THE SIZEWELL C PROJECT
NNB Generation Co (SZC) Ltd

EN010012

SUMMARY OF WRITTEN REPRESENTATION and
EXPERT REPORT

A critical review of SZC Co's site characterisation, impact assessment, and proposals for impact mitigation, in relation to the risks posed to the ecohydrological integrity of Sizewell Marshes SSSI

**DOCUMENT:**  
SIZEWELL C  
ENVIRONMENTAL STATEMENT  
VOLUME 2  
APPENDIX 19A  
NUMERICAL MODELLING REPORT

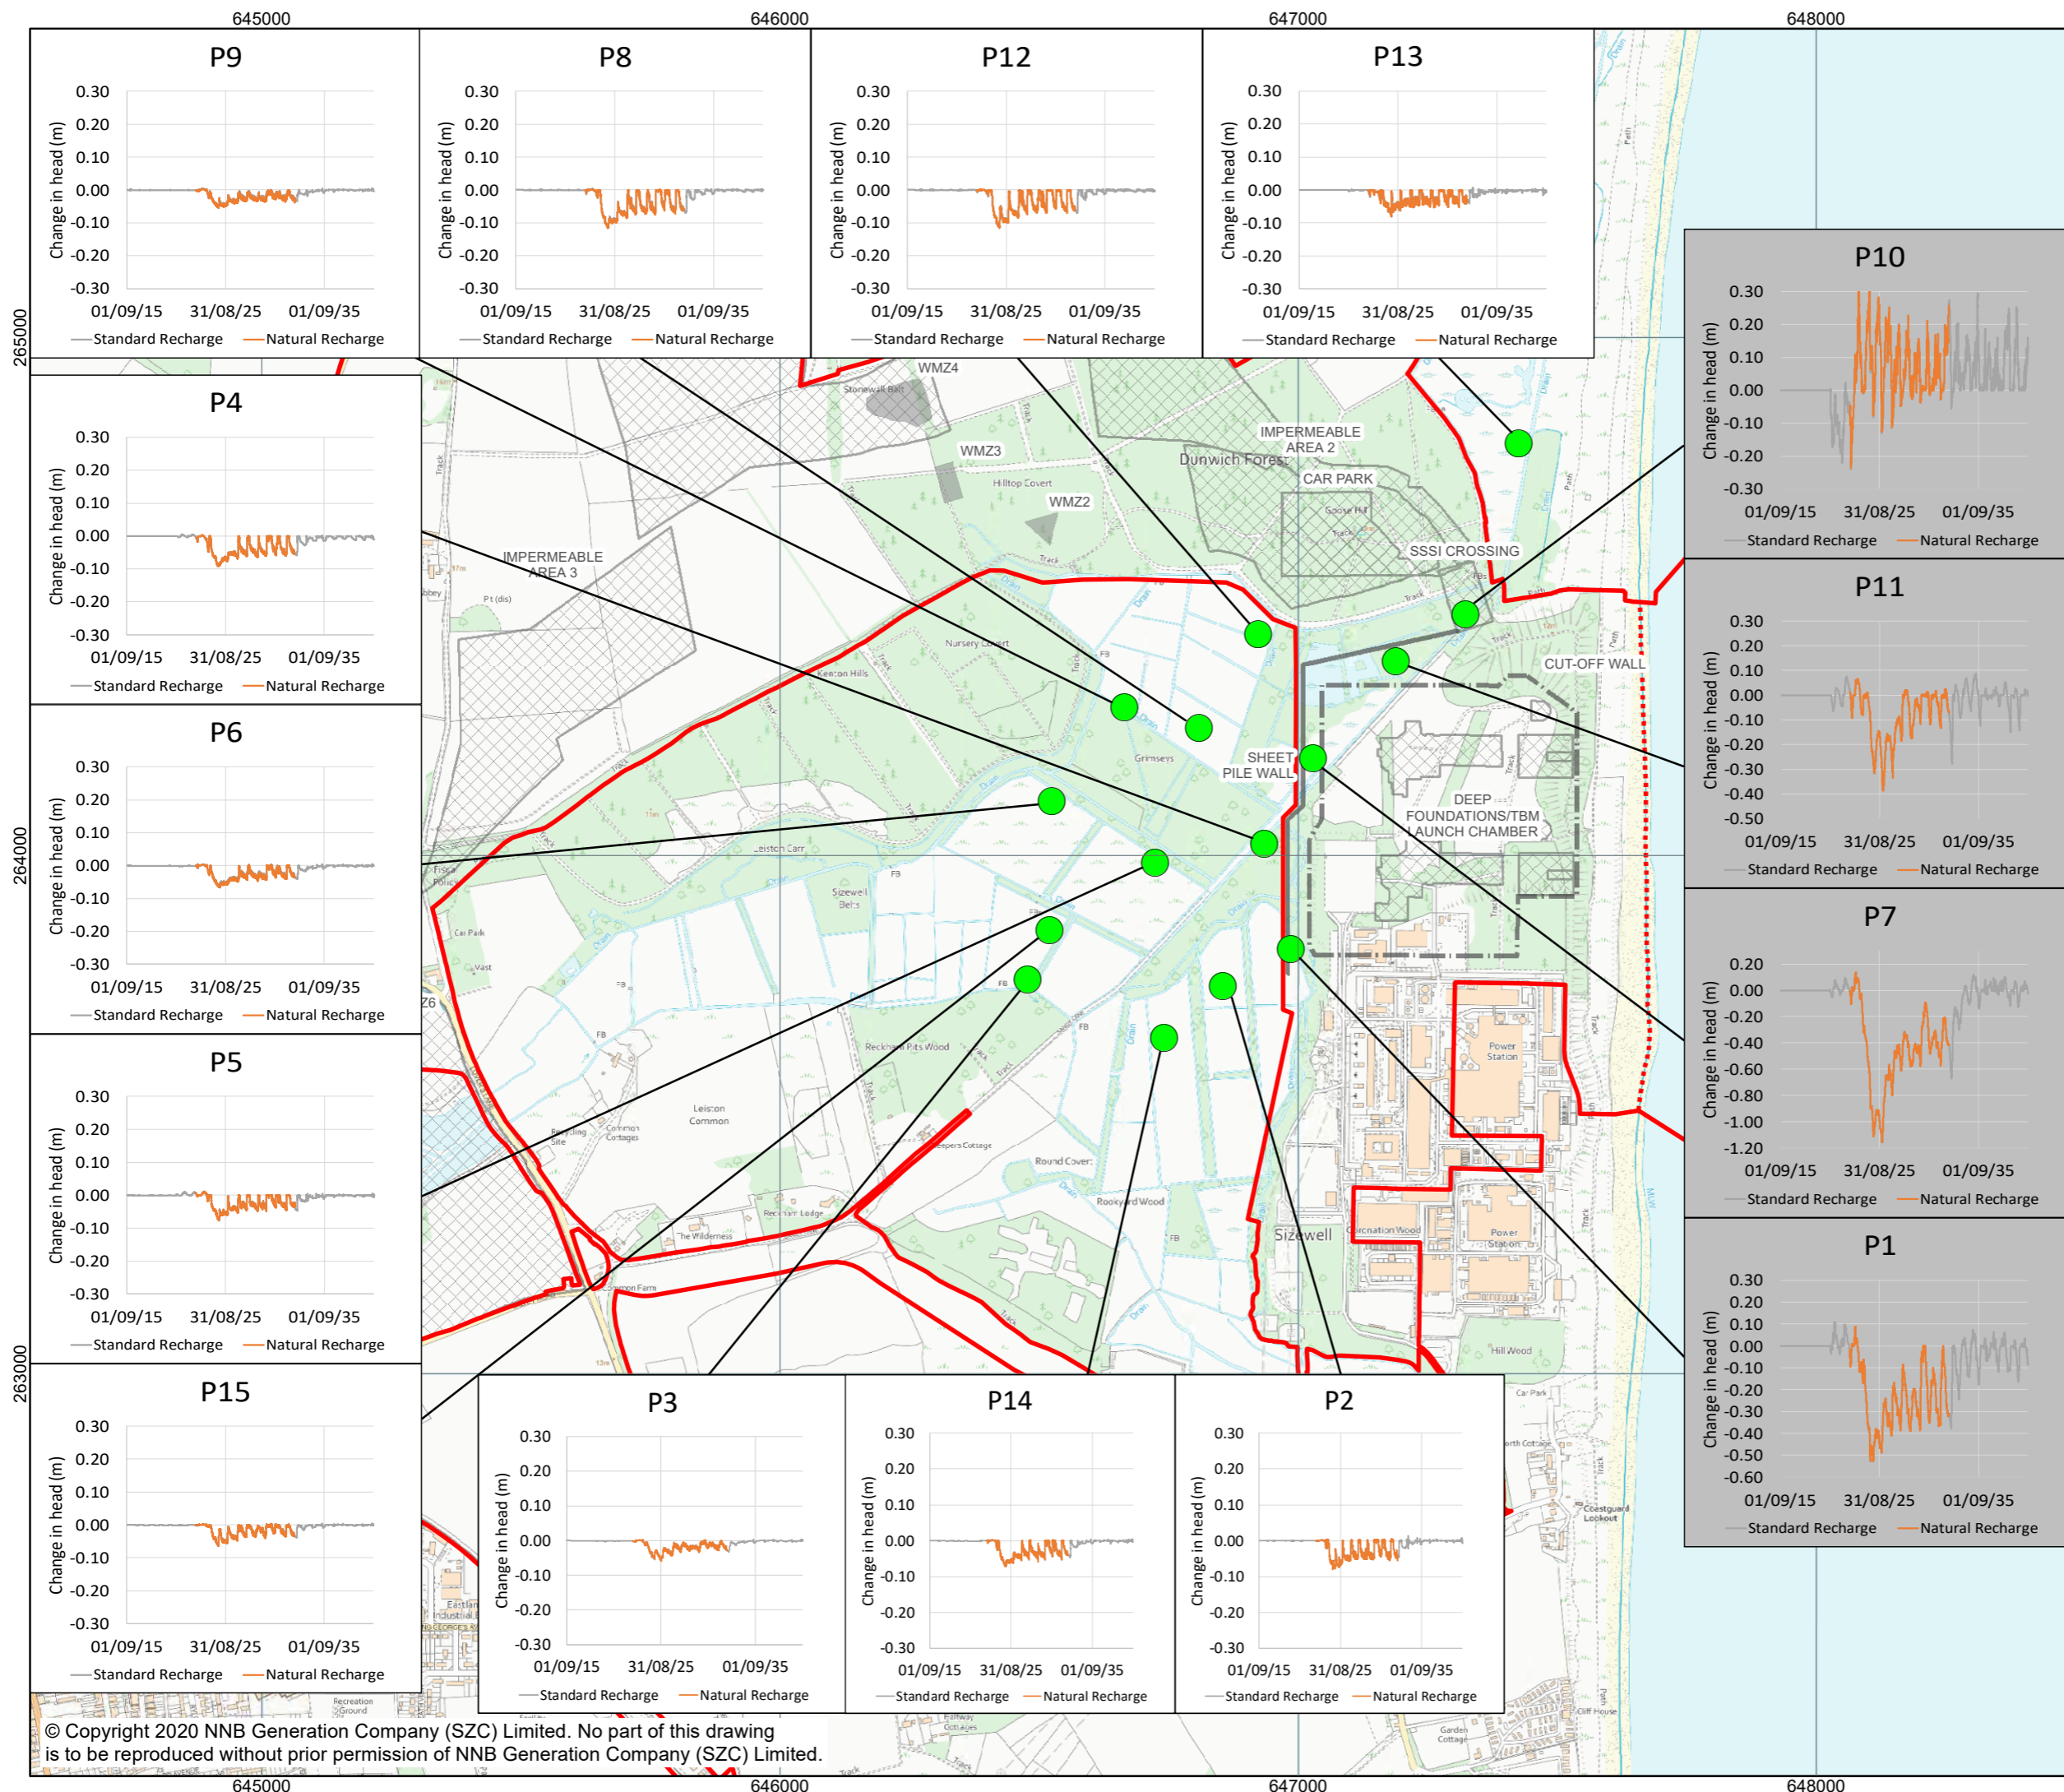
- The design of the model sensitivity analyses is overly optimistic; the effects of a three- to five-fold increase in the hydraulic conductivity of the cut-off wall should have been tested, and some (not unlikely) combinations of single sensitivity analysis scenarios should have been tested. If this had been done, it would have shown that there is a reasonable chance that projected drawdowns will be significantly larger than the base-case model, and in turn that the M22 community is potentially significantly more vulnerable to the proposed development.
